| Report title:                    | Designers response to Stage 1 Road Safety Audit, Pagham South Local Centre |
| Date:                            | 14 <sup>th</sup> February 2022                                             |
| Document reference and revision: | 2152/RSA/DR/02                                                             |

A Stage 1 Road Safety Audit (ref: 211206) was produced by Avon Traffic & Safety Services on 14<sup>th</sup> February 2022 with regards to the proposed spine road and local centre access at land west of Pagham Road, Pagham, West Sussex. The scope of the survey also included an indicative access to a future school with associated waiting and loading restrictions (double yellow lines and school keep clear markings), the access to the school and associated road markings will be confirmed as part of a forthcoming planning application for the school.

NOTES:
© Crown copyright and database rights 2021 OS Licence 100054544.

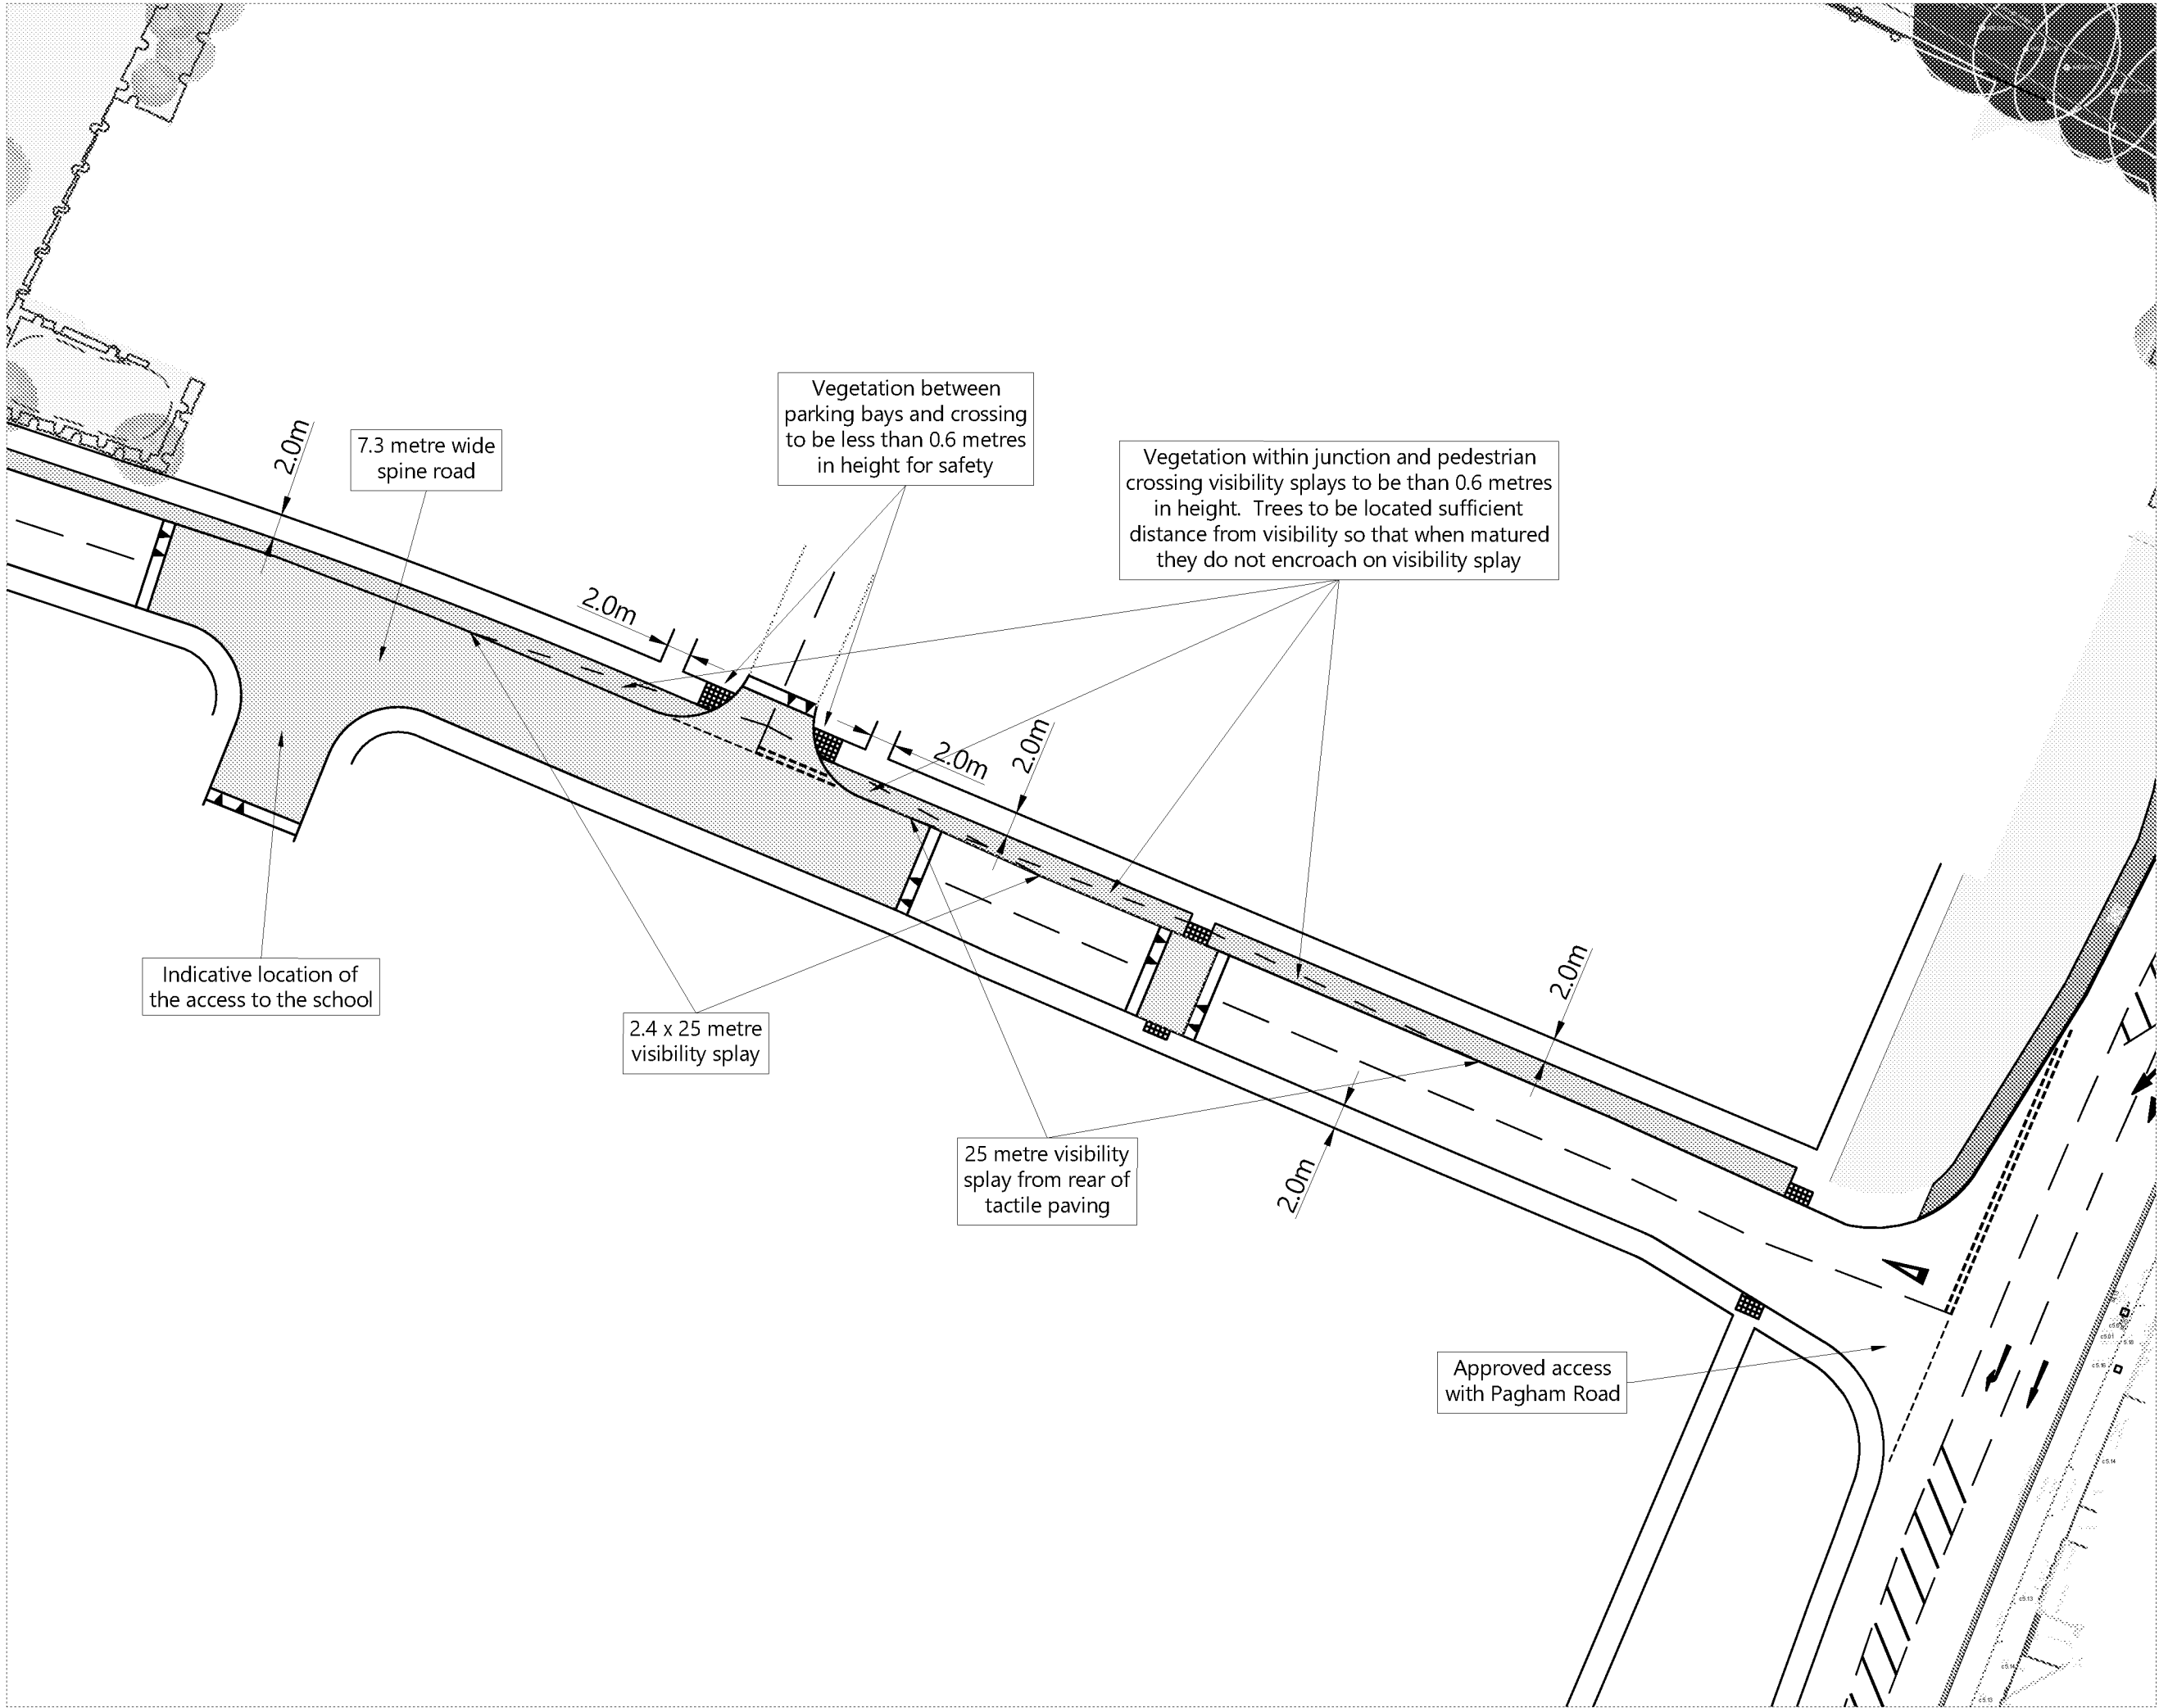
| RSA issue                                                                                                                                                                                                                                                                                                                    | RSA recommendation                                                                               | Design response                                                                                                                                                                                                       | Organisation | Overseeing Organisation response                                                                                                                                                                                                                               | Agreed RSA action                                                                |
|------------------------------------------------------------------------------------------------------------------------------------------------------------------------------------------------------------------------------------------------------------------------------------------------------------------------------|--------------------------------------------------------------------------------------------------|-----------------------------------------------------------------------------------------------------------------------------------------------------------------------------------------------------------------------|--------------|----------------------------------------------------------------------------------------------------------------------------------------------------------------------------------------------------------------------------------------------------------------|----------------------------------------------------------------------------------|
| <p>Speed table at west end of site</p> <p>It is not clear if the spine road will be a bus route, however if it is, the proposed speed table is not bus-friendly, as it is not long enough for a bus to completely mount the table before leaving the far side. The resultant motion could cause injury to bus passengers</p> | If the spine road is to be a bus route, extend the speed table to a minimum length of 6.0 metres | Accepted – It is not yet known if the spine road will form a bus route. However, there are no material downsides in providing the lengthened raised table as suggested and this is now shown on the updated drawings. |              | It's considered unlikely that the internal road support a regular bus service; this possibility hasn't been identified through the agreed design principles. The designer has nevertheless agreed to the auditors recommendation.. This is acceptable to WSCC. | The speed table referred is to be extended in length to a minimum of 6.0 metres. |

| RSA problem                                                                                                                                                                                                                                                                                                                                                                                                                         | RSA recommendation                                          | Design Organisation response                                                                                                                                                                                                                                                                                                                                                                      | Overseeing Organisation response                                                                                                                              | Agreed RSA action                                                                                                                     |
|-------------------------------------------------------------------------------------------------------------------------------------------------------------------------------------------------------------------------------------------------------------------------------------------------------------------------------------------------------------------------------------------------------------------------------------|-------------------------------------------------------------|---------------------------------------------------------------------------------------------------------------------------------------------------------------------------------------------------------------------------------------------------------------------------------------------------------------------------------------------------------------------------------------------------|---------------------------------------------------------------------------------------------------------------------------------------------------------------|---------------------------------------------------------------------------------------------------------------------------------------|
| <p>School Keep Clear markings, south side of spine road</p> <p>The School Keep Clear markings are shown to the east of the school entrance only, meaning that parents' vehicles will legally be able to stop and wait to pick up/drop off students to the immediate west of the entrance. In this position they could obscure pedestrians crossing south to north, such that they would risk being struck by westbound vehicles</p> | Add School Keep Clear markings to west of the school access | <p>Accepted – School Keep Clear markings have been provided to the west of the indicative school access.</p> <p>It should be noted that the school access shown is indicative and when the school application is brought forward the access will be designed in detail. This will include the extents of road markings to ensure the continued safe operation of the spine road and accesses.</p> | <p>The Designers response is noted and agreed.</p> <p>It's recognised that the school access and associated road markings may be amended at a later time.</p> | No further action required at this stage. The extent of School Keep Clear markings should be reviewed as part of the detailed design. |

| RSA problem                                                                                                                                                                                                                                                                                                                                                                                                                                                                                                                                                 | RSA recommendation                                                                                                             | Design Organisation response                                                                                                                                 | Overseeing Organisation response                                                                                                                                                          | Agreed RSA action                                                                                                        |
|-------------------------------------------------------------------------------------------------------------------------------------------------------------------------------------------------------------------------------------------------------------------------------------------------------------------------------------------------------------------------------------------------------------------------------------------------------------------------------------------------------------------------------------------------------------|--------------------------------------------------------------------------------------------------------------------------------|--------------------------------------------------------------------------------------------------------------------------------------------------------------|-------------------------------------------------------------------------------------------------------------------------------------------------------------------------------------------|--------------------------------------------------------------------------------------------------------------------------|
| <p>Spine Road, north side between proposed waiting restrictions and the bend at west end of audit site</p> <p>It is possible that school parking will extend along the north side of the spine road from the end of the proposed restrictions, over the speed table (which is an informal pedestrian crossing point) and around the inside of the bend. Parked vehicles in this area will obstruct the view to the west of pedestrians waiting to cross north to south on the speed table, such that they would risk being struck by eastbound vehicles</p> | Extend the waiting restrictions westward from the proposed end point, to a point adjacent to the next junction around the bend | Accepted – Waiting restrictions have been provided through the northern side of the pedestrian crossing and its visibility splays to the west of the school. | Although the Developer's strategy for managing school related parking is currently unclear, which may in turn affect the extent of waiting restrictions, the Designers response accepted. | No further action is required at this stage. The waiting restrictions should be implemented through the detailed design. |

| RSA problem                                                                                                                                                                                                                                                                                                                                                                                                                    | RSA recommendation                                                                                                            | Design Organisation response                                                                                                                                 | Overseeing Organisation response            | Agreed RSA action                                                                                                        |
|--------------------------------------------------------------------------------------------------------------------------------------------------------------------------------------------------------------------------------------------------------------------------------------------------------------------------------------------------------------------------------------------------------------------------------|-------------------------------------------------------------------------------------------------------------------------------|--------------------------------------------------------------------------------------------------------------------------------------------------------------|---------------------------------------------|--------------------------------------------------------------------------------------------------------------------------|
| <p>Speed table at west end of site</p> <p>It is possible that school parking will extend along the south side of the spine road from the end of the proposed restrictions, over the speed table (which is an informal pedestrian crossing point). If this occurs, pedestrians crossing south to north on the speed table will be obscured by parked vehicles, such that they would risk being struck by westbound vehicles</p> | Provide a short length of waiting restrictions on the south side of the spine road, to protect the speed table/crossing point | Accepted – Waiting restrictions have been provided through the southern side of the pedestrian crossing and its visibility splays to the west of the school. | The Designers response is noted and agreed. | No further action is required at this stage. The waiting restrictions should be implemented through the detailed design. |

| RSA problem                                                                                                                                                                                                                                                                                                                                                                                                                                                                                                                                                                                | RSA recommendation                                                      | Design Organisation response                                                                                                                                                                                                                                                                                                                                                                                                                                                                                                                | Overseeing Organisation response                                                                                                                                                                                                                                                                                                                                                                                                                                                               | Agreed RSA action                                                                                                        |
|--------------------------------------------------------------------------------------------------------------------------------------------------------------------------------------------------------------------------------------------------------------------------------------------------------------------------------------------------------------------------------------------------------------------------------------------------------------------------------------------------------------------------------------------------------------------------------------------|-------------------------------------------------------------------------|---------------------------------------------------------------------------------------------------------------------------------------------------------------------------------------------------------------------------------------------------------------------------------------------------------------------------------------------------------------------------------------------------------------------------------------------------------------------------------------------------------------------------------------------|------------------------------------------------------------------------------------------------------------------------------------------------------------------------------------------------------------------------------------------------------------------------------------------------------------------------------------------------------------------------------------------------------------------------------------------------------------------------------------------------|--------------------------------------------------------------------------------------------------------------------------|
| <p>School Keep Clear markings</p> <p>SKC restrictions only relate to the carriageway on which they are marked, and so their restriction does not extend to the back of footway in the same way that double yellow lines do. With a smaller upstand of the speed table than a conventional kerb, there is a danger that drivers will park on the footway adjacent to the speed table and parking enforcement would then not be able to take place if vehicles are clear of the SKC. This could cause conflict issues for pedestrians. Furthermore, parking in these areas would only be</p> | Continue the double yellow lines through the School Keep Clear markings | <p>Partially Accepted – Waiting restrictions have been provided alongside school keep clear markings through the raised table to restrict obstructive parking on the verge and/or footway.</p> <p>It is however not accepted that planning enforcement would be unable to take action if parking occurred outside of the hours of operation as they would be covered by Rule 243 of the Highway Code <i><b>"DO NOT stop or park ...opposite or within 10 metres (32 feet) of a junction, except in an authorised parking space"</b></i></p> | <p>The Designers response regarding the extension of the waiting restrictions is noted and agreed.</p> <p>WSCC however point out that the rule within the Highway Code is not legally enforceable, but more good practice. Unless there are enforceable restrictions vehicles could park within 10 metres of a junction. The exception to this is only where a parked vehicle is causing an obstruction, which can be dealt with under Section 99 of the Road Traffic Regulation Act 1984.</p> | No further action is required at this stage. The waiting restrictions should be implemented through the detailed design. |

| prohibited during school hours, so vehicles could be parked here overnight and on weekends. To ensure that these areas are legally protected at all times, the double yellow lines would need to be continued through the School Keep Clear markings |  |  |  |  |
